December 24, 2024

Re: Freddy's at 4315 Wyoming Blvd NE
Erosion and Sediment Control Plan
Engineer's Stamp Date: missing (G19E004G)

James D. Hughes, P.E.
Principal Engineer, Planning Dept.
Development and Review Services

ESC-1

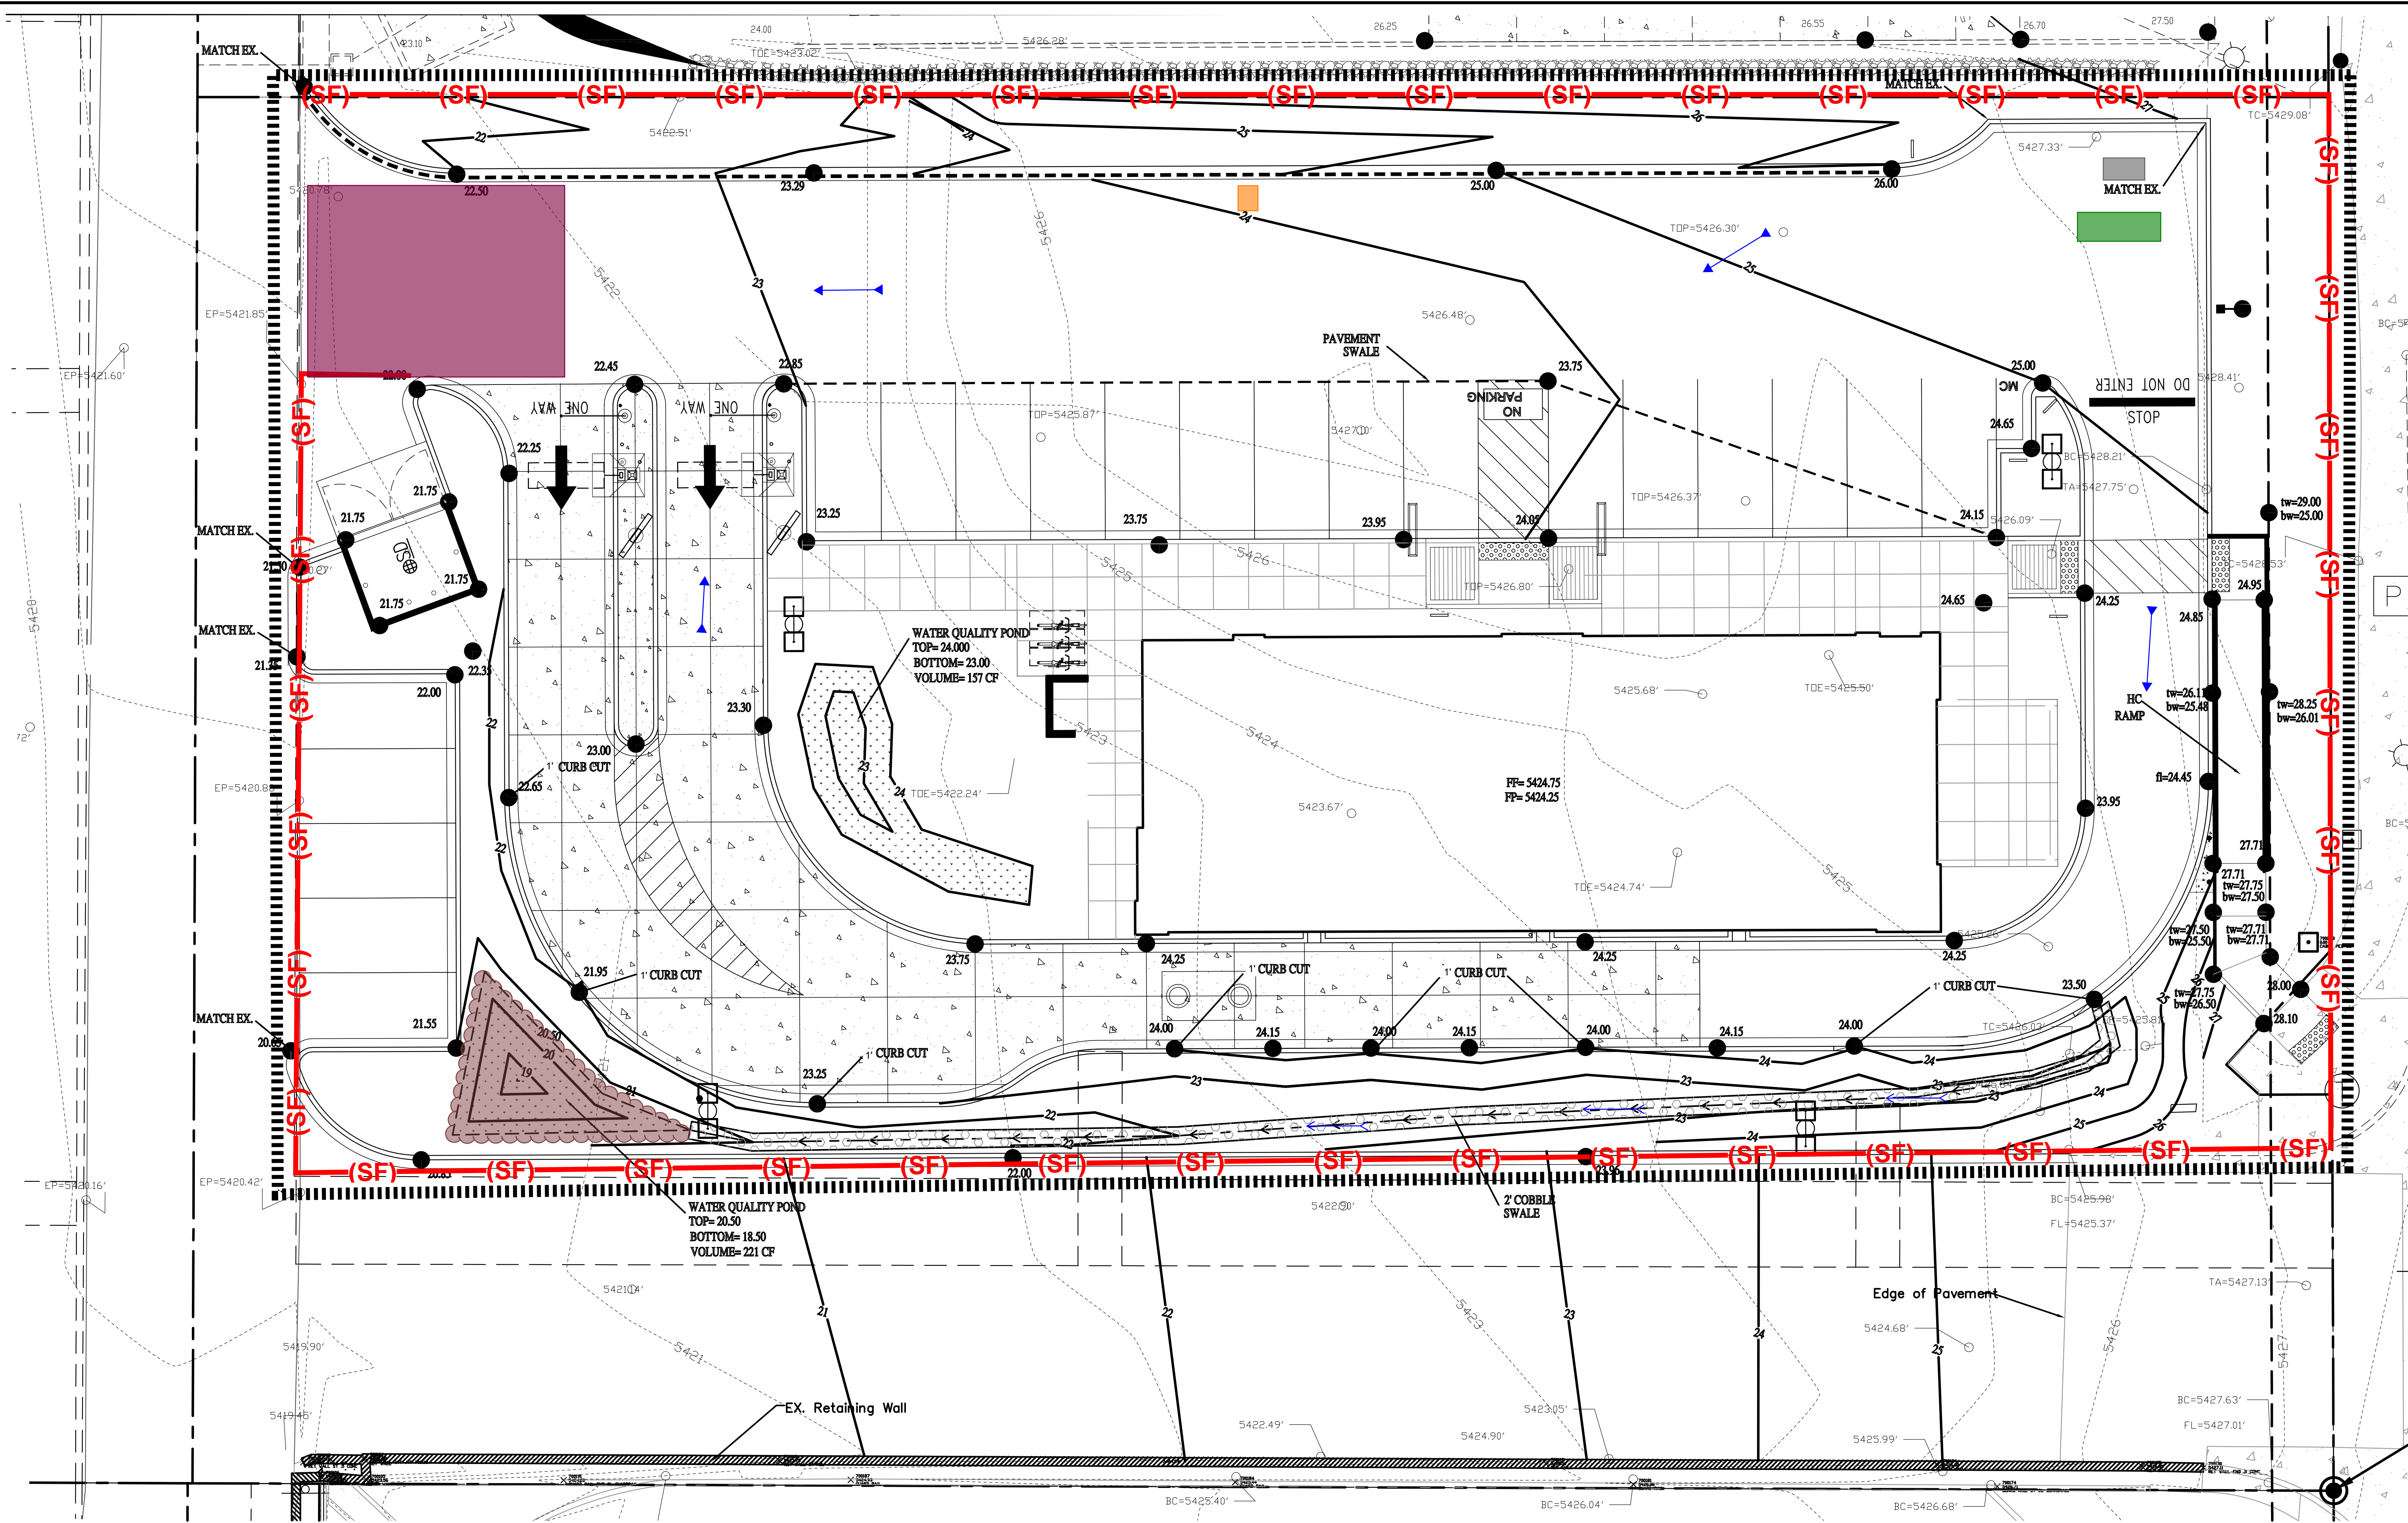
2. A legend showing the limits of disturbance and BMPs is missing and is required by the drafting standards and must be shown on the ESC Plan.
3. The Limits of Land-Disturbing Activities are missing from the ESC Plan. You must accurately identify the location of limits of disturbance on the ESC Plan. Be sure to include any offsite construction support activities in the limits.

4. The Construction Exit (CE) isn't allowed at the handicap ramp on Wyoming Blvd. as currently shown on the ESC Plan. A more likely location is at the end of the existing paved driveway onto Wyoming Blvd. Relocate the CE on the ESC Plan and provide dimensions and construction specifications. Make sure that traffic can't bypass the CE. The location, dimensions, and construction specifications are still missing.

9. The Silt Fence (SF) locations are inaccurate, encroaching into the existing driveways on the north and west sides, and SF isn't needed along the existing wall on the south side of the site.
